16 July 2019

File No: R/2016/32/C
Our Ref: 2019/335158

Barangaroo South Stage 1B Public Domain Works – SSD 7944 MOD 1

WATERMANS COVE RAISED PLANTER

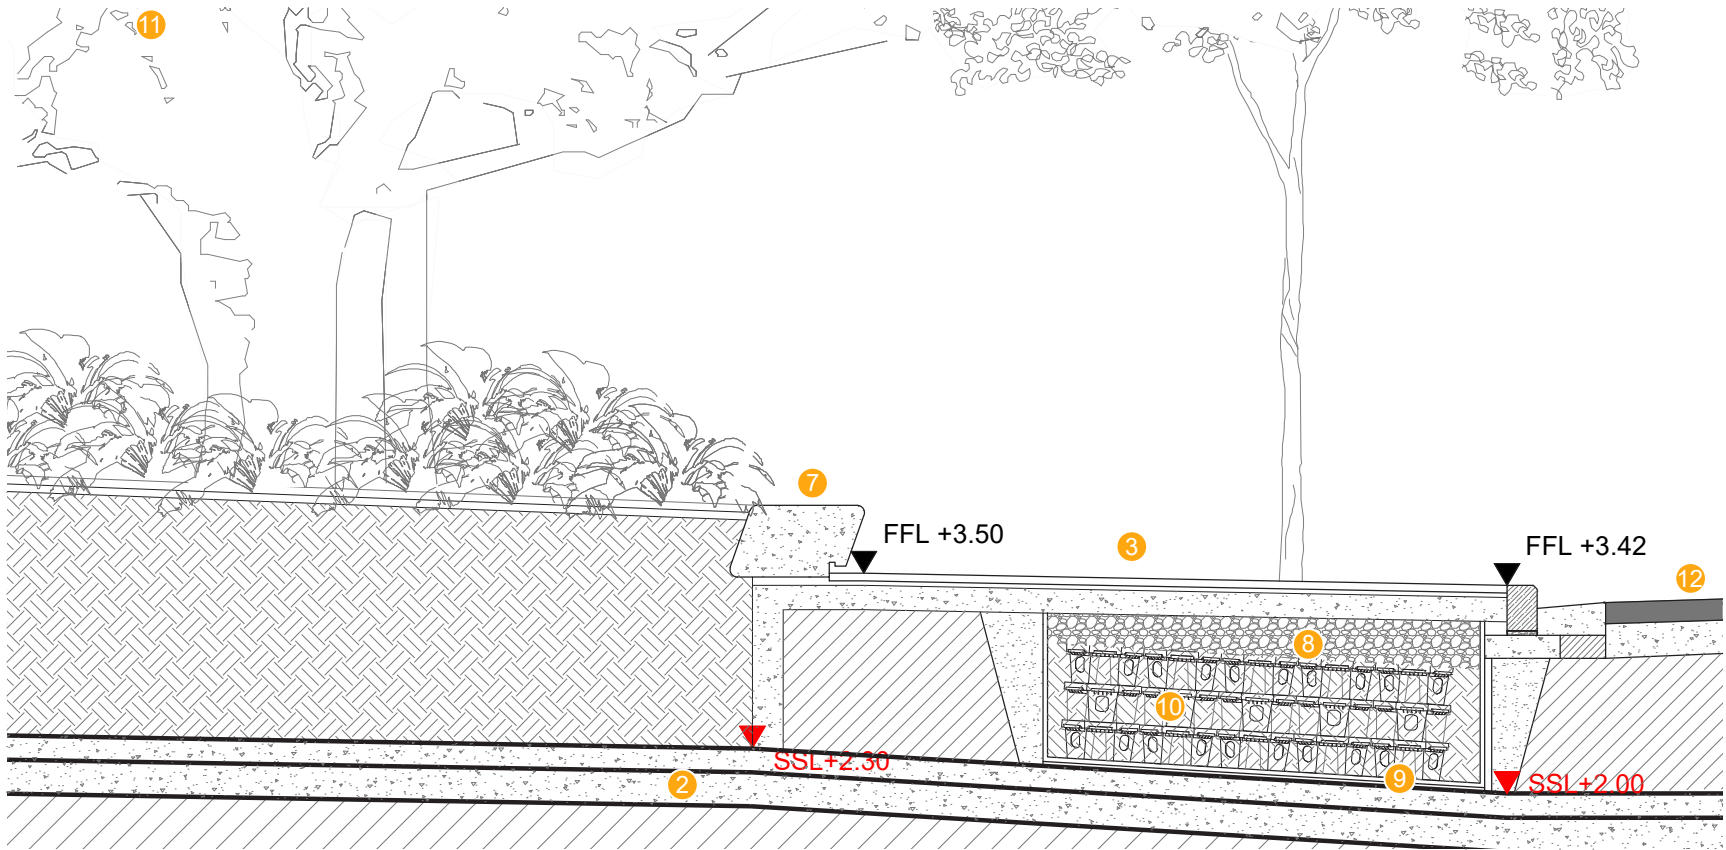
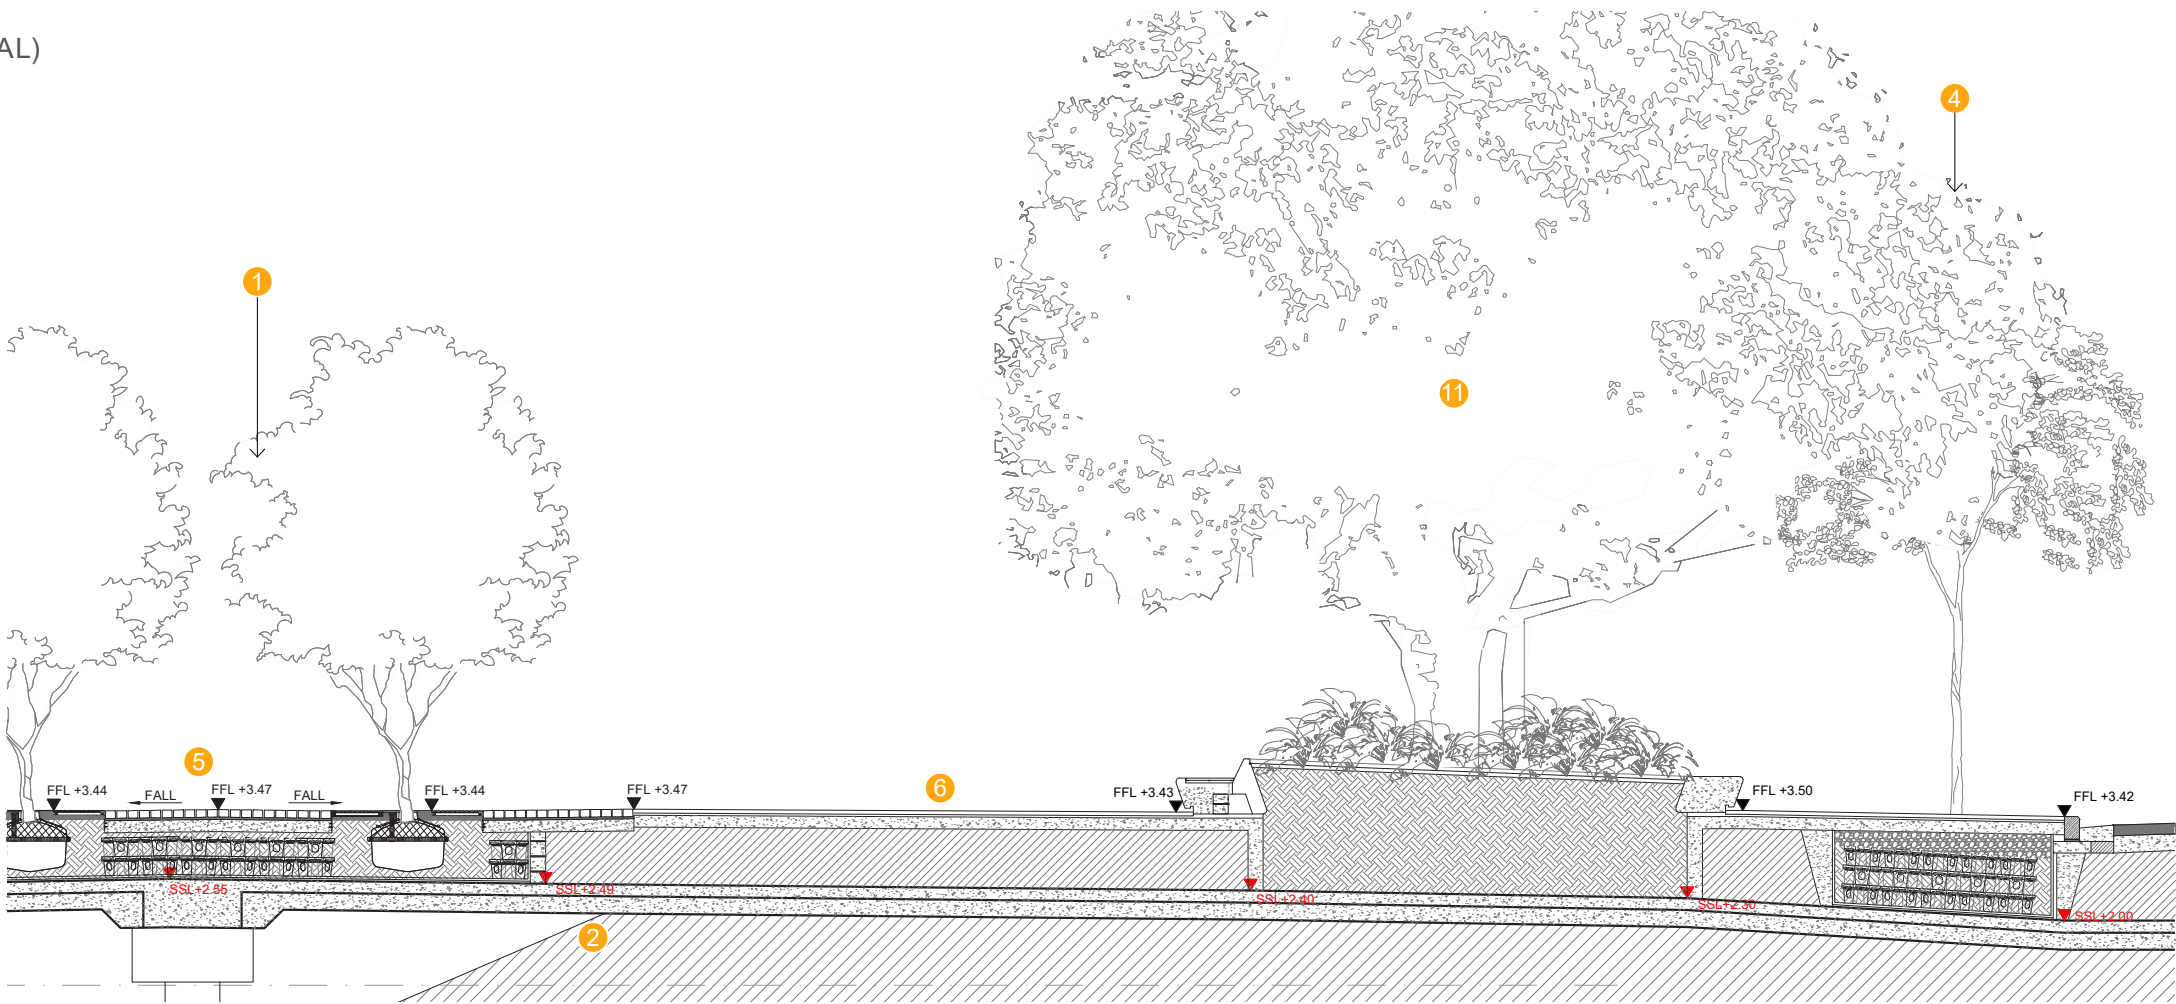
- The modification deletes the timber seating and does not provide an alternative design with comfort in mind, the proposal is simply a concrete planter edge. No details of the planter have been provided.
- The deletion of timber seating and backrests to the signature feature Fig tree planters is not supported. These feature trees are located in Waterman Cove, Barangaroo Avenue, Spirit of Tasmania Loading Dock and Watermans Quay.
- Elsewhere the signature fig trees are in raised sandstone planters and the City of Sydney timber benches are proposed in the streets.

HICKSON ROAD BOLLARD STRATEGY

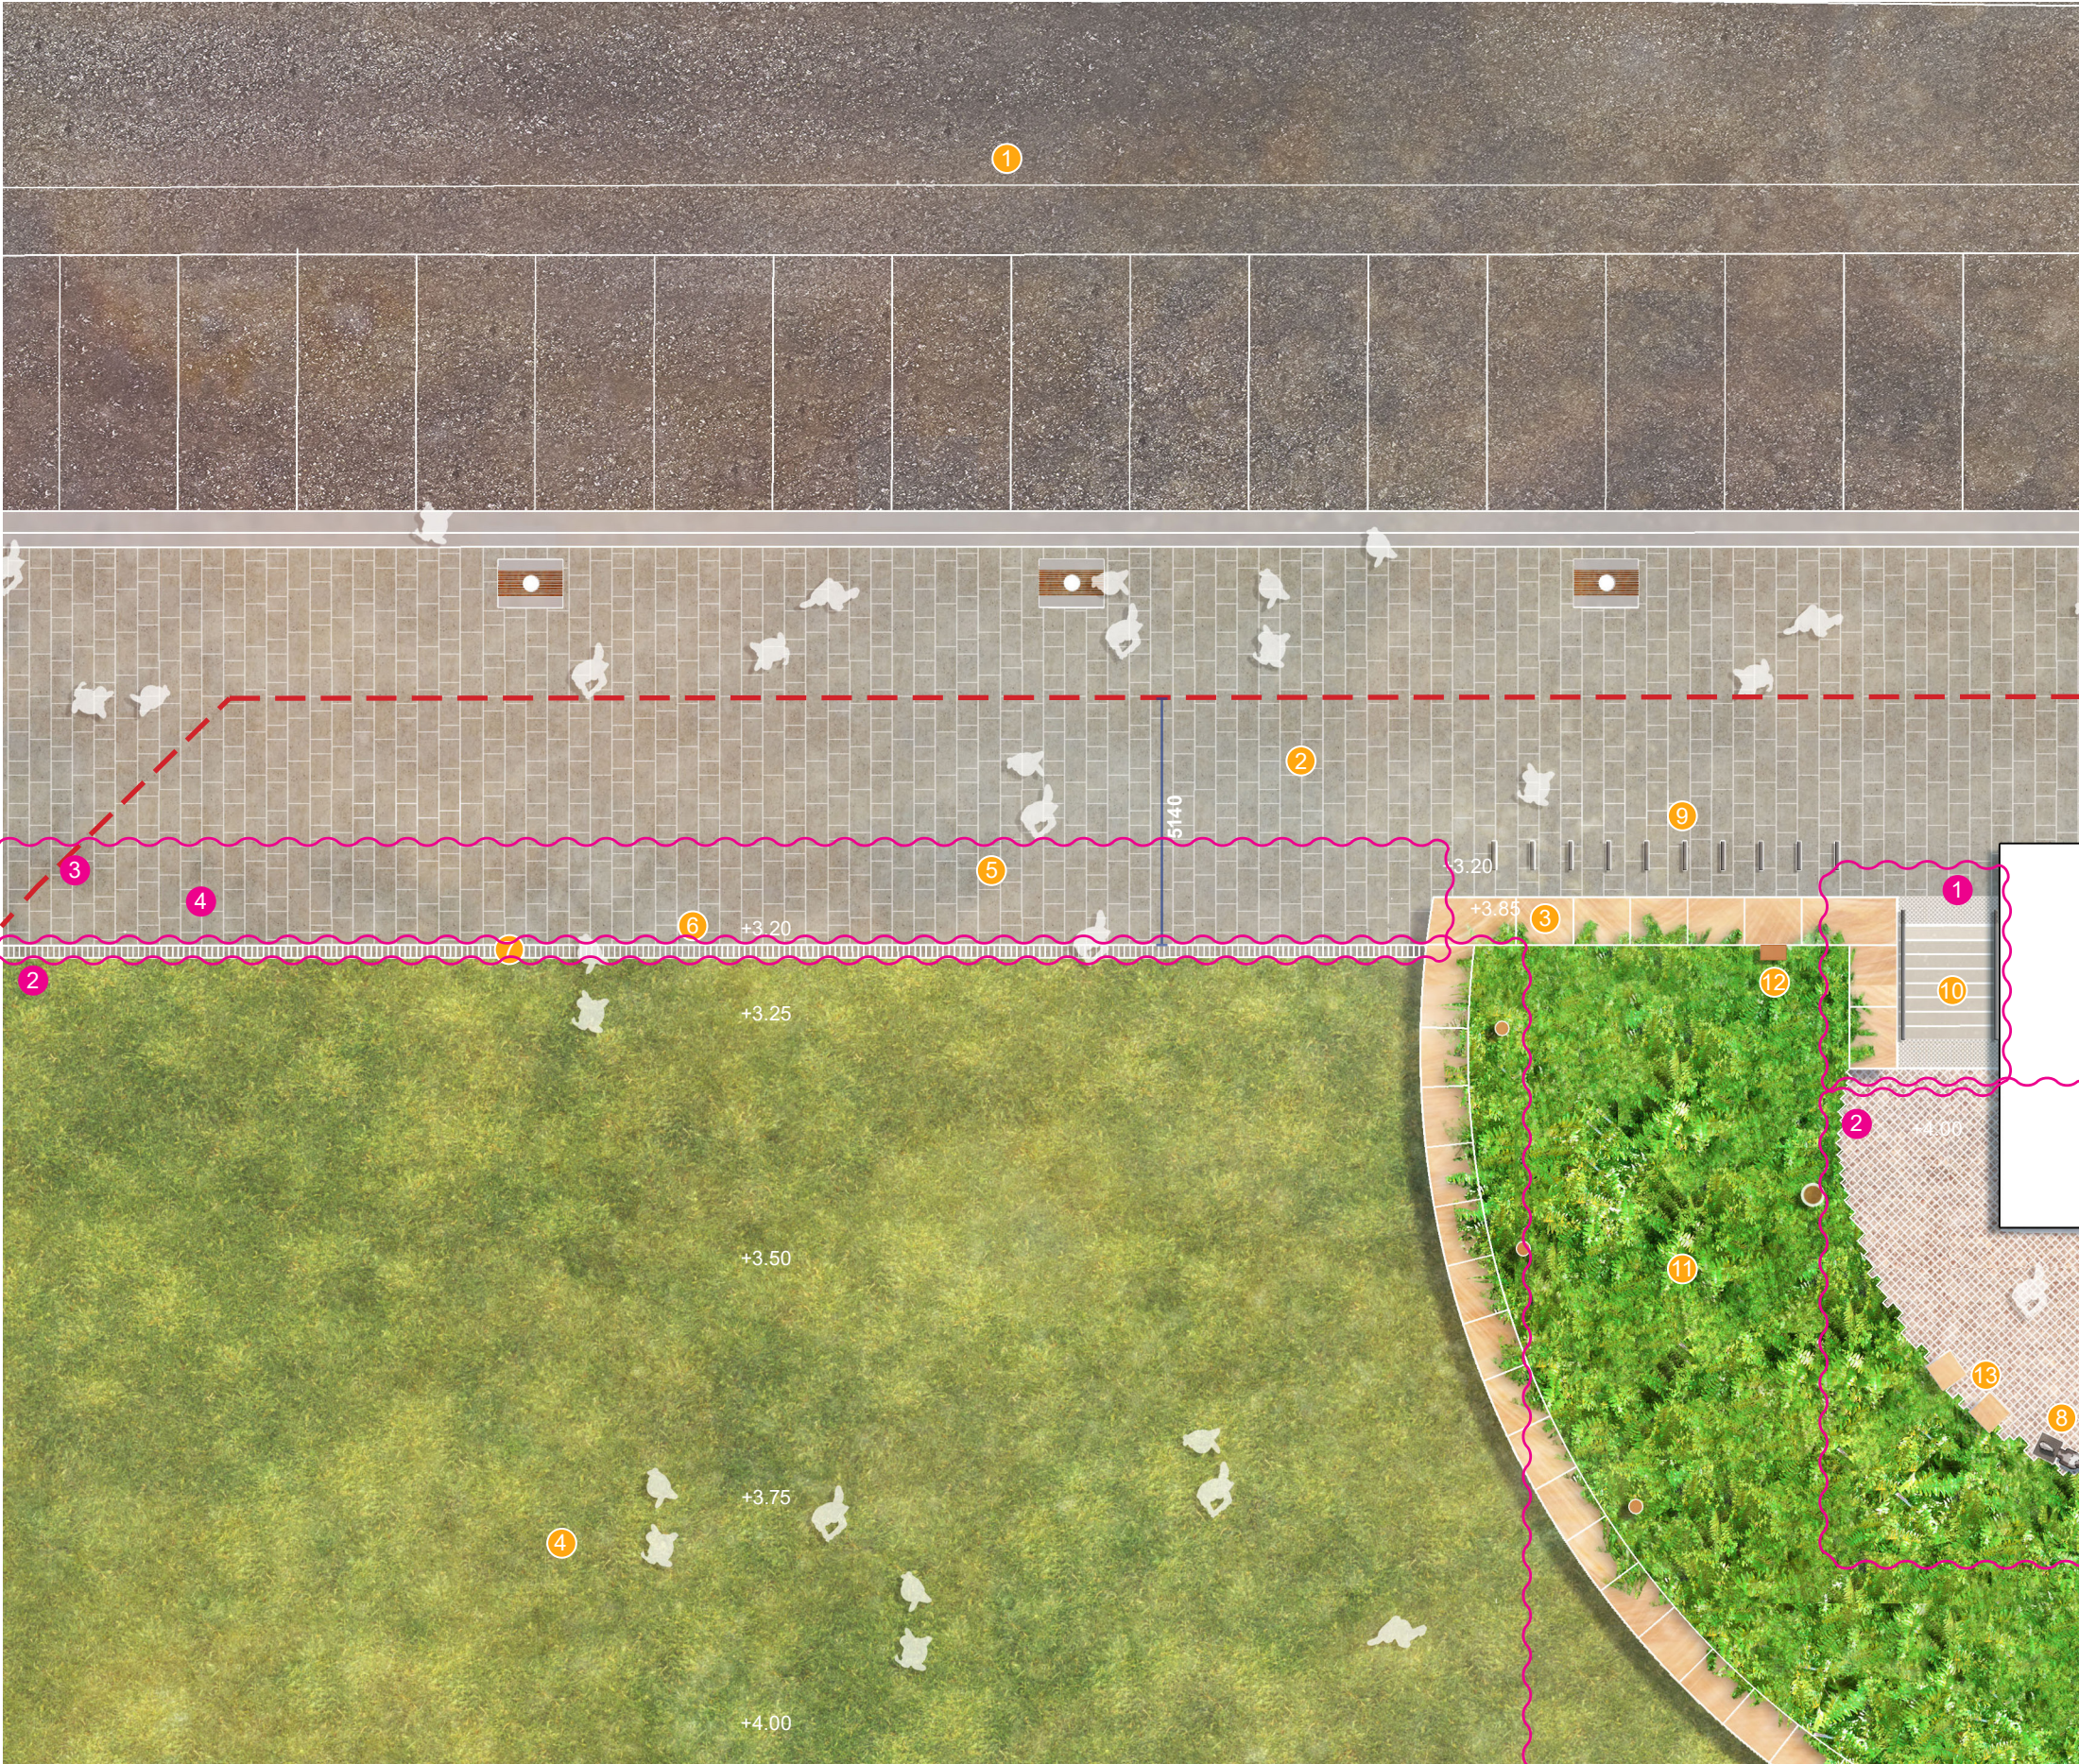
- On Barangaroo Avenue and Watermans Quay entries, the design of barriers against hostile vehicle attacks presented in April 2018 were a “sculptural sandstone seating element and vehicle deterrent” using local sandstone. The design was to act as seating, public art and be a playful edge to the public Hickson Park.

Like the barriers on Hickson Road, the proposed low concrete blocks have little design finesse. Further, there is no justification for the reduction in quality of materials and design. The substitution is not supported.

- Alternate methods of ensuring protection for park users while retaining permeability are encouraged to be explored.
- The applicant is to produce a public domain plan in consultation with Council's Public Domain Unit that focuses on footways and the interface with adjacent roads, particularly the final treatment for Hickson Road
- The applicant is to consult with Council's Public Domain unit to prepare suitable stormwaters overland flow path calculations and design, drainage systems, on-site detention measures and stormwater quality assessments. The stormwater quality design/report for the proposed development shall comply with Council's MUSIC Link model. The certificate/report from the MUSIC Link model and the electronic copy of MUSIC Model shall be submitted to Council for review and approval.
